WEST SUSSEX COUNTY COUNCIL CONSULTATION

TO:	Arun District Council FAO: Amber Willard
FROM:	WSCC - Highways Authority
DATE:	28 June 2022
LOCATION:	Stoneyfield Cottages, Eastergate Lane, Eastergate, PO20 3SL
SUBJECT:	BN/48/22/PL Variation of condition imposed under BN/112/21/PL relating to condition 2-plans condition.
DATE OF SITE VISIT:	N/A
RECOMMENDATION:	Advice
S106 CONTRIBUTION TOTAL:	N/A

FOR MR & MRS MITCHELL		
SITE SITE AT: STONEFIELD NURSERY, EASTERGATE LANE, EASTERGATE. PO20 3SL		
TITLE SITE PLAN SHOWING PROPOSED DWELLING		
SCALE 1:100 © A2	DATE 03/22	DRAWING NO. 01P REV C

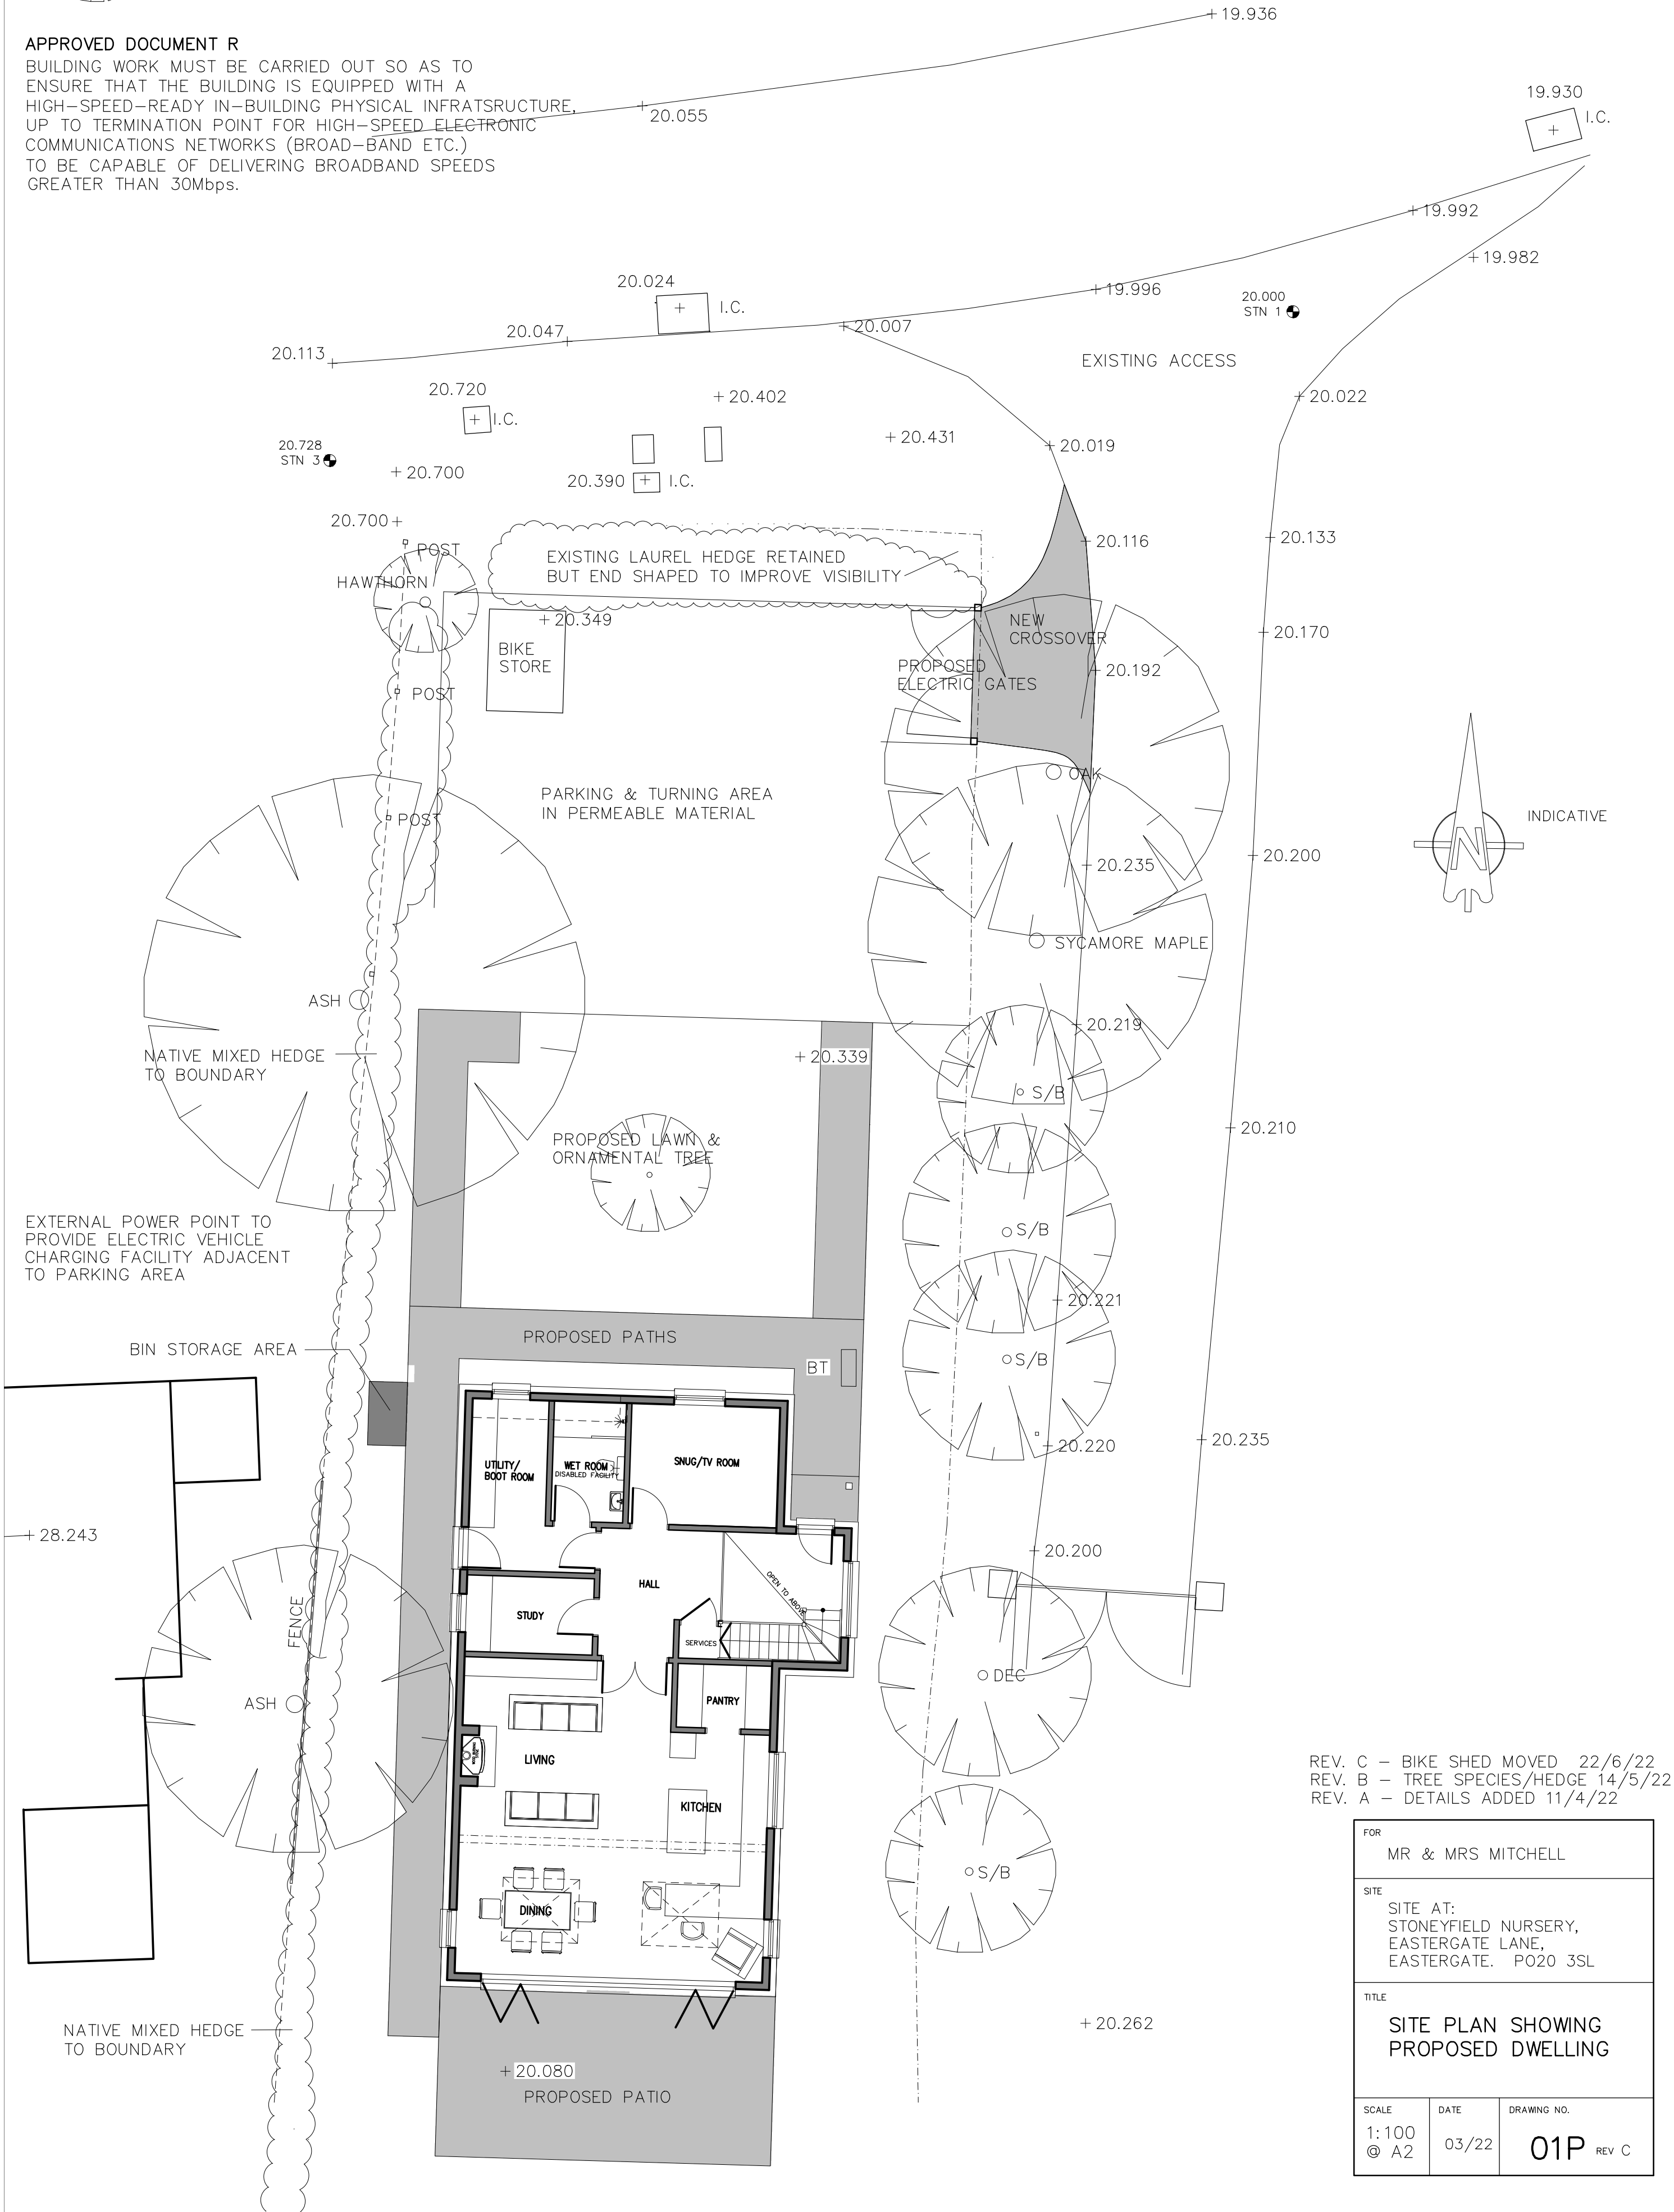
Following an inspection of the amended plans, the applicant has retained the location of the proposed access. However, the existing laurel hedge to the north of the access is to be shaped to improve visibility. Taking this into consideration, and that the private access road is anticipated to generate a relatively low number of movements, the LHA accepts the amended proposals. The LHA request that the laurel hedge be maintained in perpetuity to ensure visibility does not become obstructed.
